**SYDNEY OLYMPIC PARK AUTHORITY
DESIGN REVIEW PANEL
ADVICE SHEET**

Project	3.1 – Site 9, Proposed Mixed use Development
Presentation / Review Date	3 December 2015
Panel Present	Peter Poulet Bill Tsakalos Caroline Pidcock Peter Mould John Choi Darlene van der Breggen
COI Declaration	None.
Also Present	Ben Woods - SOPA
Presenters	Guy Lake (BatesSmart) Matthew Allen (BatesSmart) Bassam Aflak (Ecove) Michael Azar (Ecove)
Documents made available	Power Point Presentation
Inherited decisions	Special exception to allow for above ground parking
Previous relevant SOPA Advice	DRP meeting 82, 20 March 2014
General Observations/ Overall Comment	The design is for a mixed residential, commercial and retail development, proposed as part of the successful RFDP bid for site 9. The design has been developed in response to the recommendations by the tender assessment team, particularly in relation to the tower form as well as resolution of the ground floor levels. (It was noted that DRP members Caroline Pidcock and Bill Tsakalos had participated in the tender assessment). The DRP was very supportive of the proposed design refinements, including the proposal to increase tower height beyond the 32 sto

Building Elevations Southwest

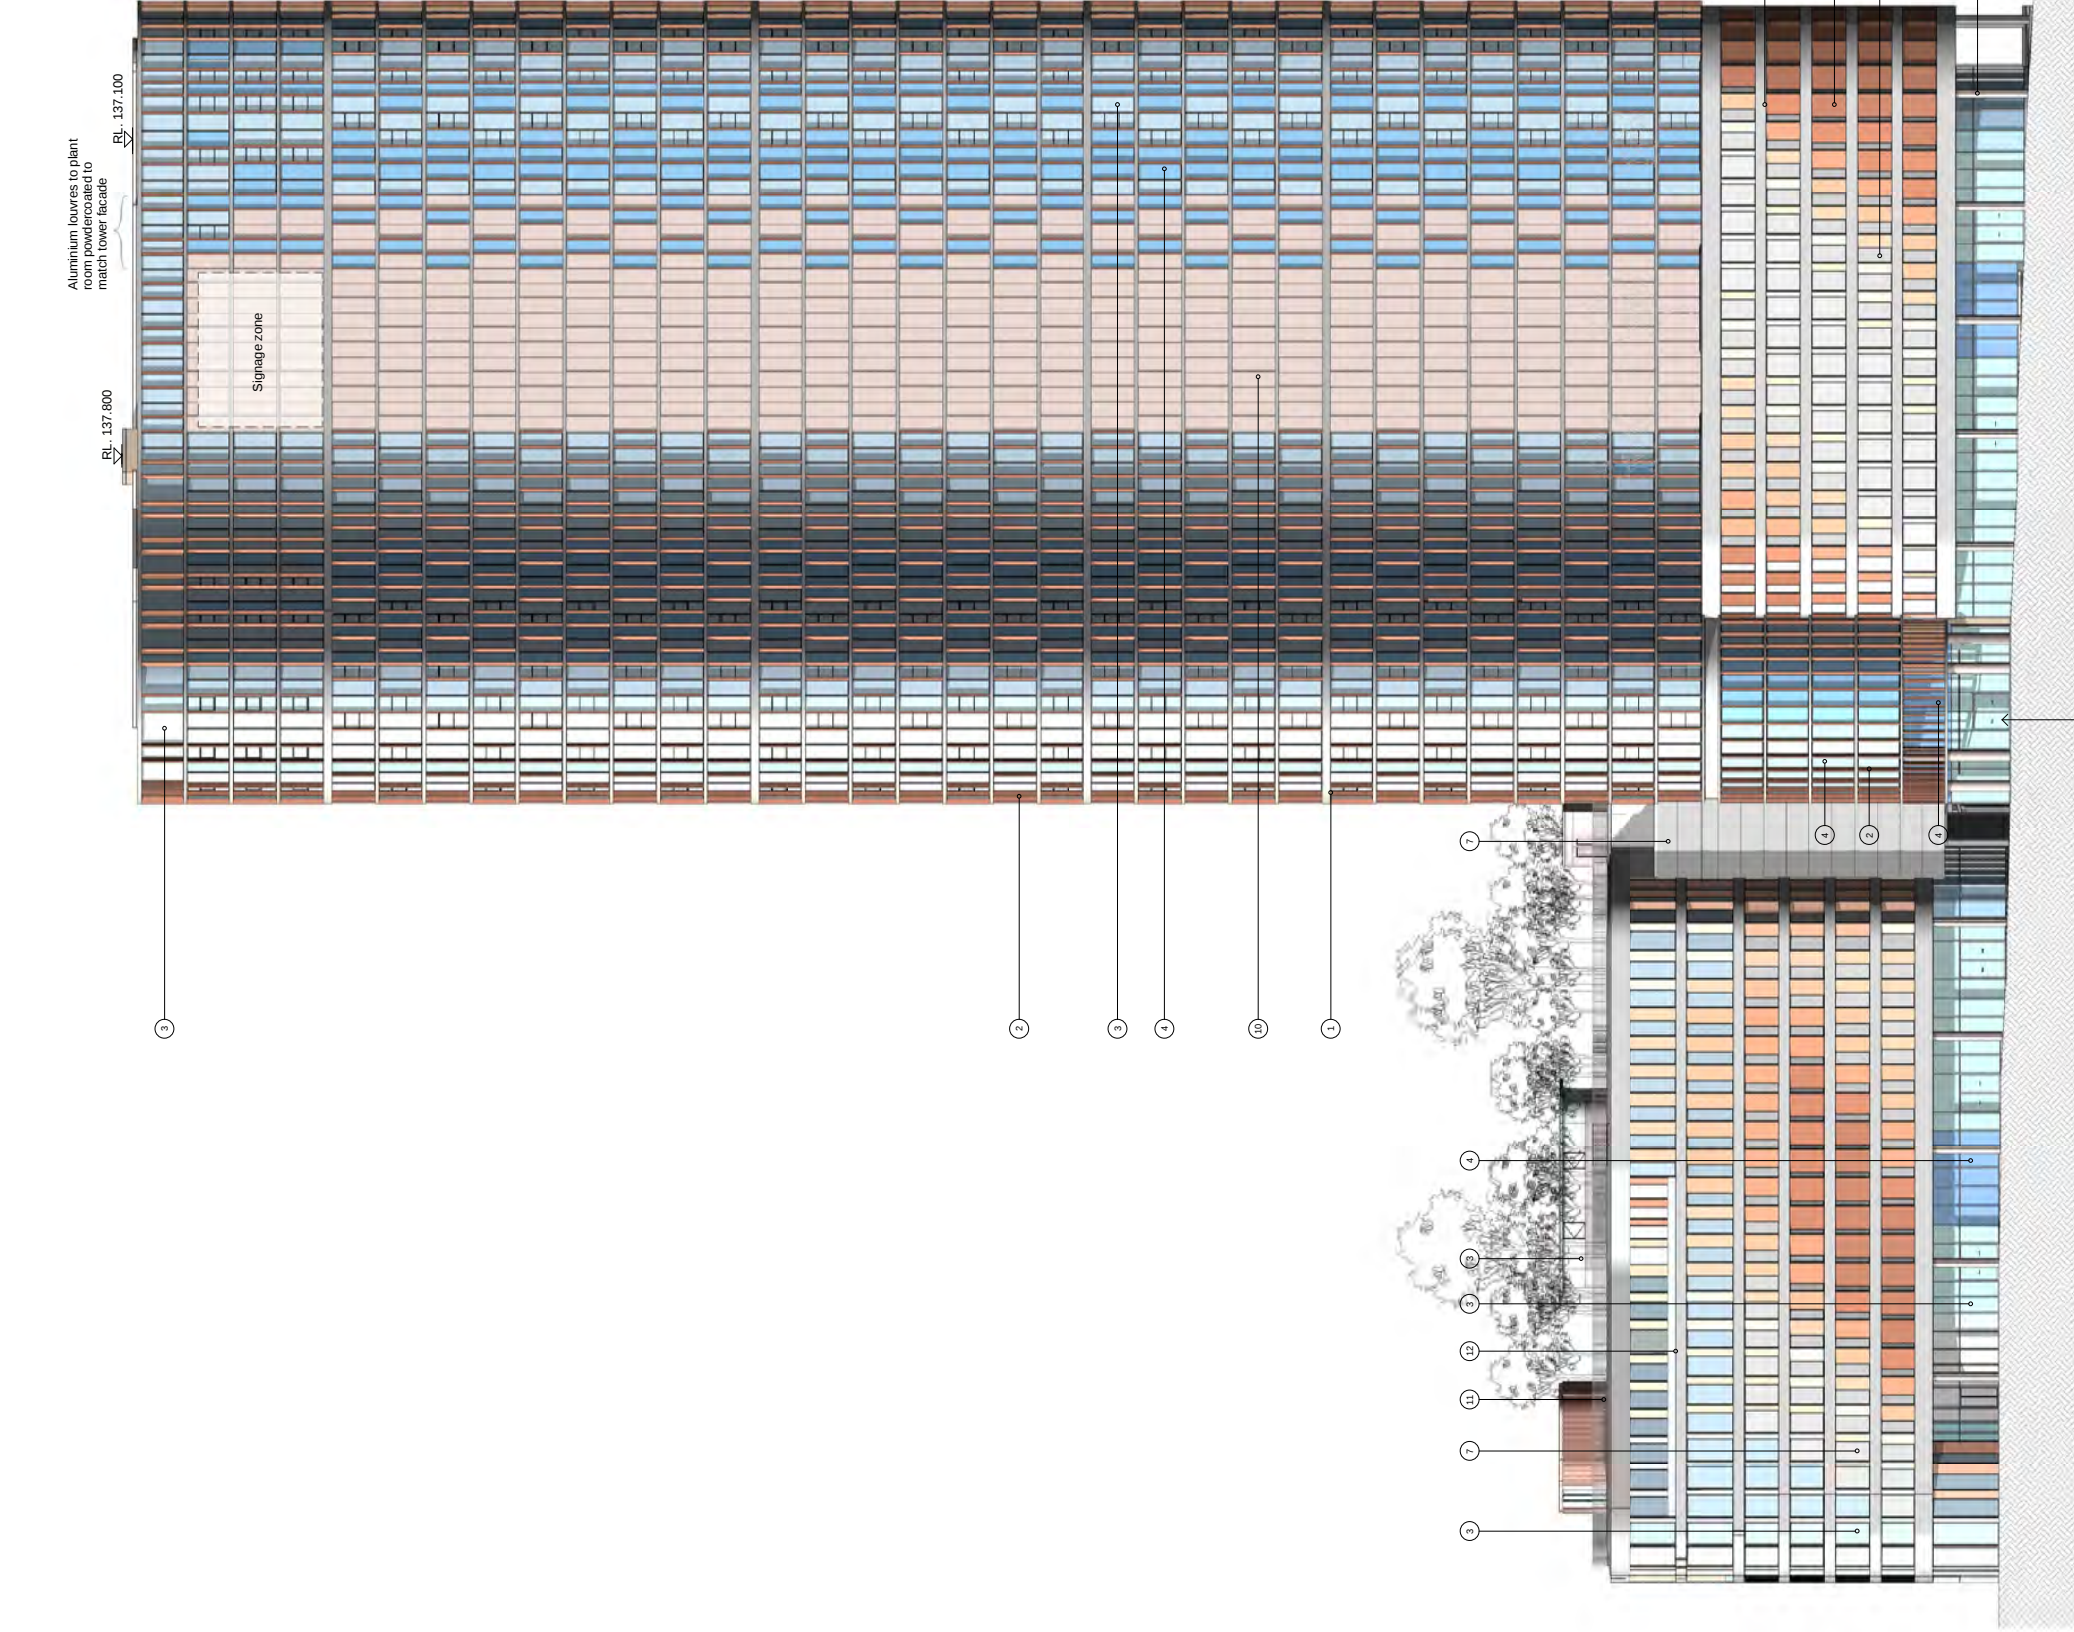
Positives	The DRP commended the 6 star Greenstar target. The DRP supported: • Improvements to ground level layout to provide more flexibility for retail / club uses, • Direct OB street address for the residential lobby. • Increased tower height to 36 stories, to enable reduction in tower floor plate area (to 700sm GFA). • Higher proportion of 3B units • Refinements to tower modeling improves slenderness
Issues	The DRP had the following concerns; • At 3m floor to floor, the above ground carpark levels will be unsuitable for conversion to other uses at some point in the future. • Proposed indentation to the southern façade needs further consideration in terms of its impact on wind turbulence on the podium

- the tower cladding is a very sleek 'skin' when a textured approach may be more suitable to mitigate wind turbulence particularly around the re-entrant façade and the core wall. - That hard monochrome surface finishes are proliferating at SOP, and that even the proposed terra cotta finishes will not provide enough warmth and colour to alleviate the extensive use of glass and metal claddings. - The scale of the colonnade – single storey is too low for a development of this scale and for the Boulevard frontage
Recommendations	The DRP recommends that: - A wind impact assessment be undertaken, with particular emphasis on coordinating with: - façade materials and configurations being investigated - shape and configuration of the south facing re-entrant façade - The southern podium - the external material and colour palette should include a greater proportion of warm colour and softer natural finishes. - investigate options for increasing the height of the colonnade to 2 storey minimum during the design development phase

Recommended Action	The DRP requested that the above issues be addressed and a further presentation to the DRP prior to lodging the application.
Recommended Supporting Action	The DRP recommended that the colonnade height be reconsidered in the SOP Master Plan 2030 (2015 review).
Circulation of Advice	SOPA, proponents
